Invalid Application

Proposal: Agricultural determination for the erection of an extension to an existing agricultural building
Location: Hand Lane End Farm Tannersmith Lane Mawdesley Ormskirk L40 2RA
Reference: 24/00118/AGR

North East ~~South~~ Facing Elevation

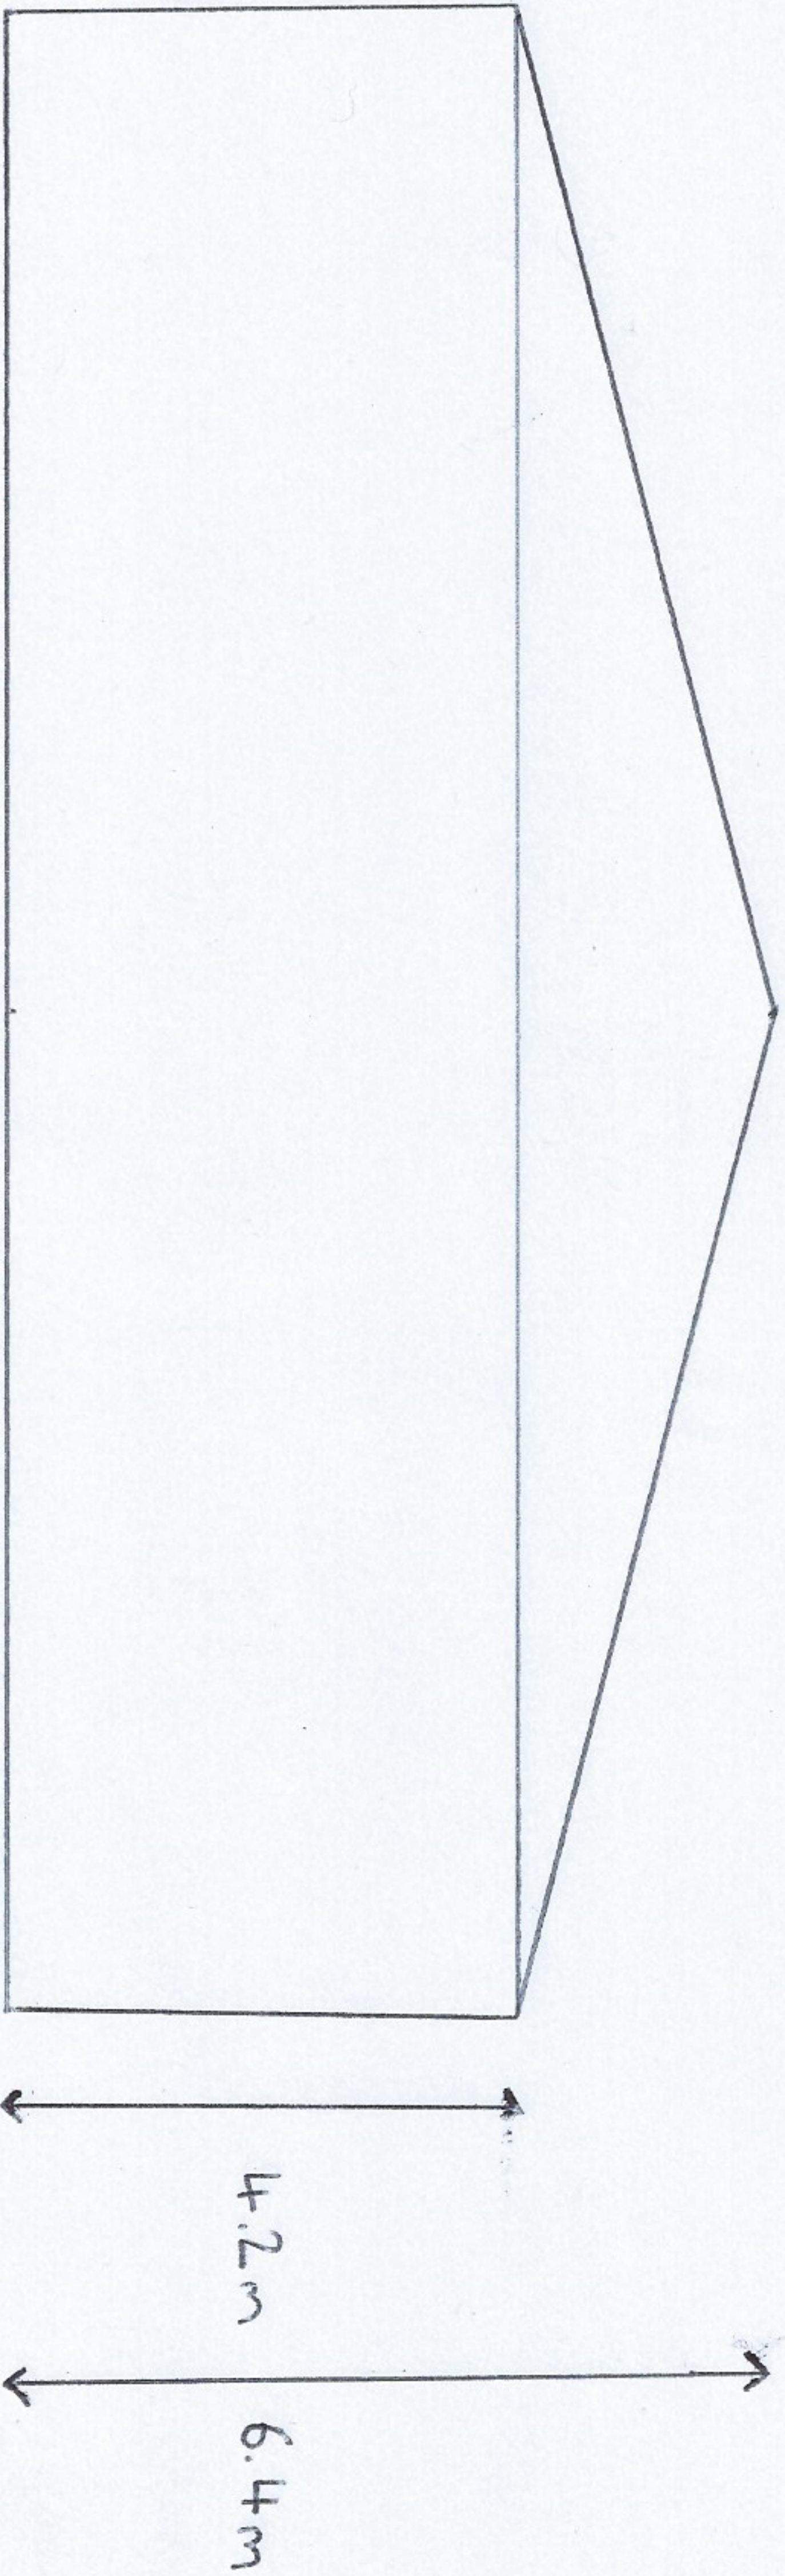
1. It is not clear from the submitted plans which part of the building is existing and which part is the proposed extension or where the proposed extension would be located in relation to the existing building. Please show the distinction between these two elements on all of the plans.
